CITY OF ALBUQUERQUE

April 24, 2015

**RE: Main Event, Pan American Freeway and Vassar Drive
Grading Plan and Drainage Plan
Engineer's Stamp Date 3-27-2015 (File: G16-D149)**

MAIN EVENT		DRAWN BY
PAN AM FREEWAY AND VASSAR AV.		BJF
GRADING PLAN		DATE
		05/14/15
		2015015_GRB
		SHEET #
		C5
		JOB #
		2015015

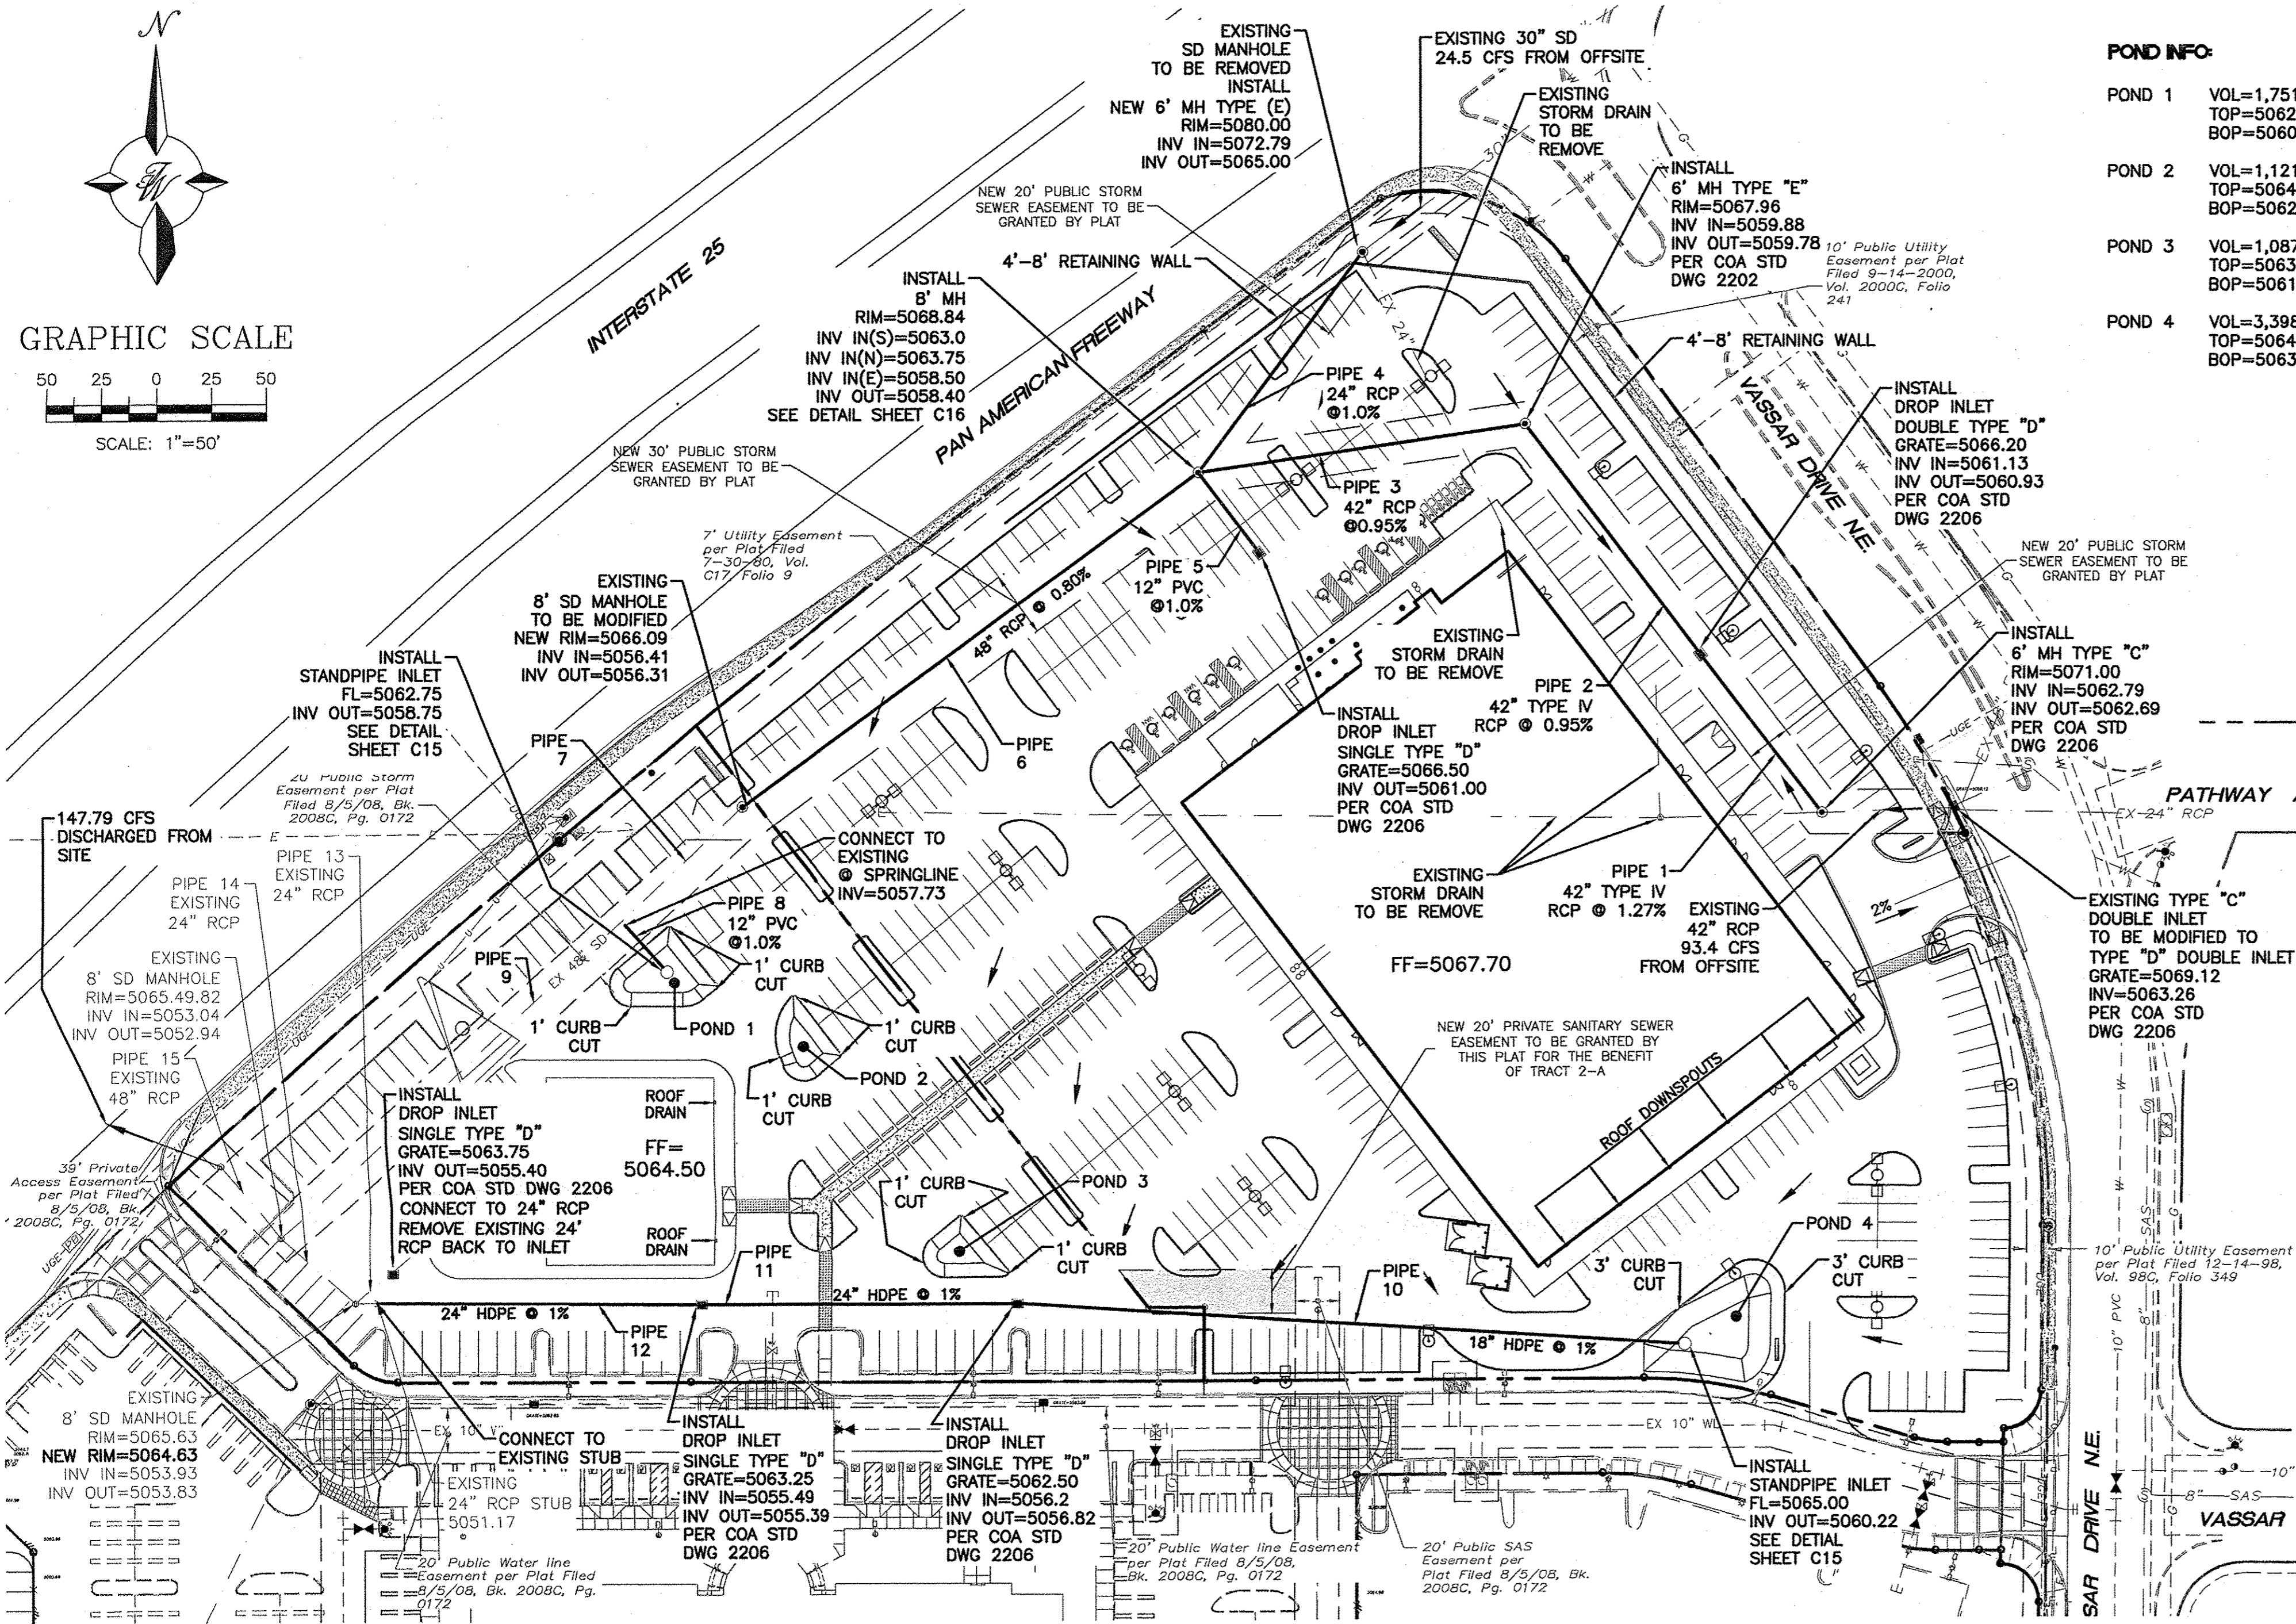
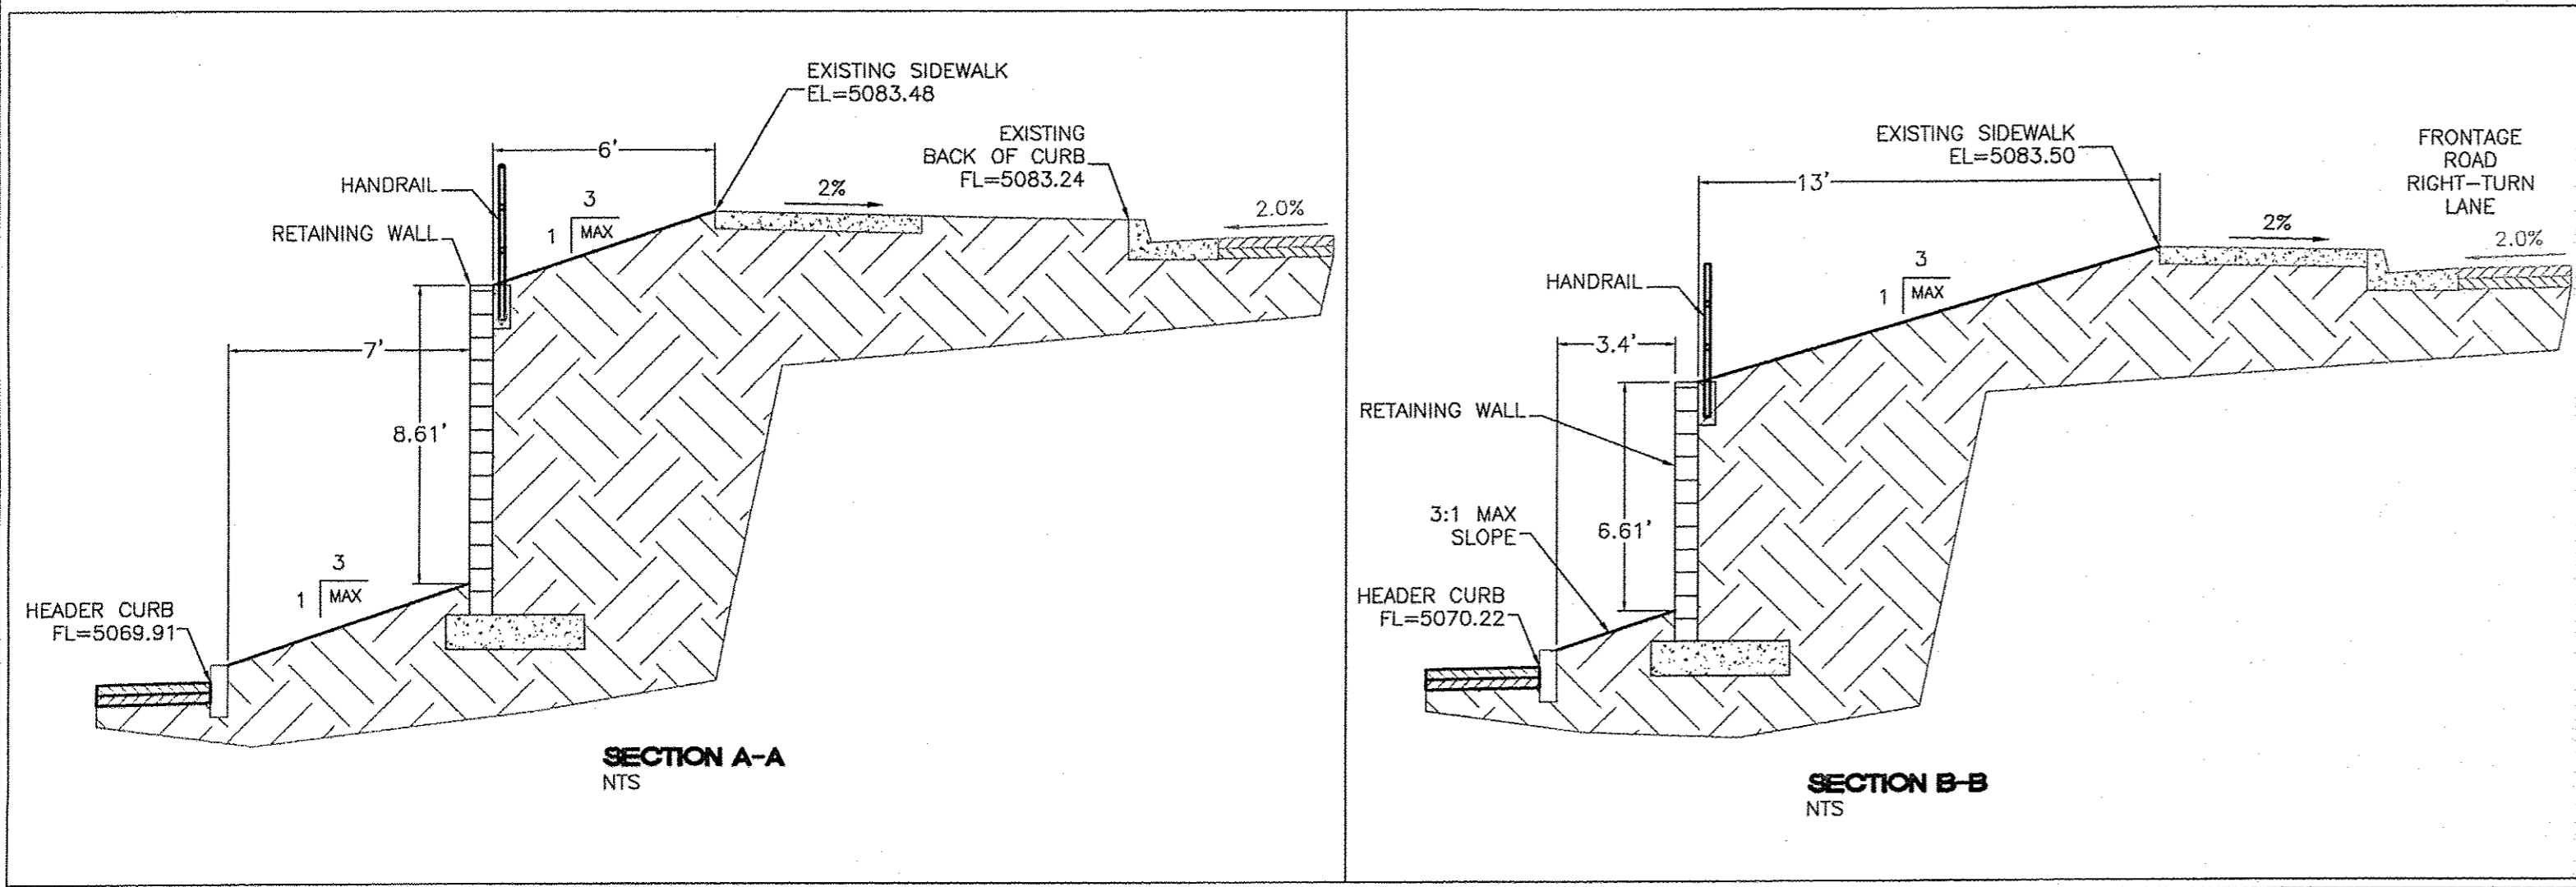
4) Include inlet capacity calculations within next submittal and inlet details. Show grate elevations for these inlets on the "Grading Plan" which correspond to the "Drainage Plan". There are a couple of discrepancies including a difference of about one foot between grate elevations and grade elevations at the same spot including two grates along the northwest side of the site that show grate elevations of 5063.75 and 5065.50.

5) Check the middle entrance to the private drive south of the building with regard to grade elevations. A couple of new spot elevations are shown to be 3 feet off from existing spot elevations, creating a very steep drop. Include more existing spot elevations within the public and private roads surrounding the site.

7) It looks like an approximate 3:1 slope is being created between the Pan American Freeway and the retaining wall along the parking lot. Provide Section A-A symbol on the plan view. There is an elevation discrepancy where the top of wall elevation is 5079.67, and there is an existing 5084.0 spot elevation as well as a 5086.90 for the new manhole rim elevation within very short distance from the wall.

9) Specify elevations in parking lot to be at bottom of curb if this is the case.
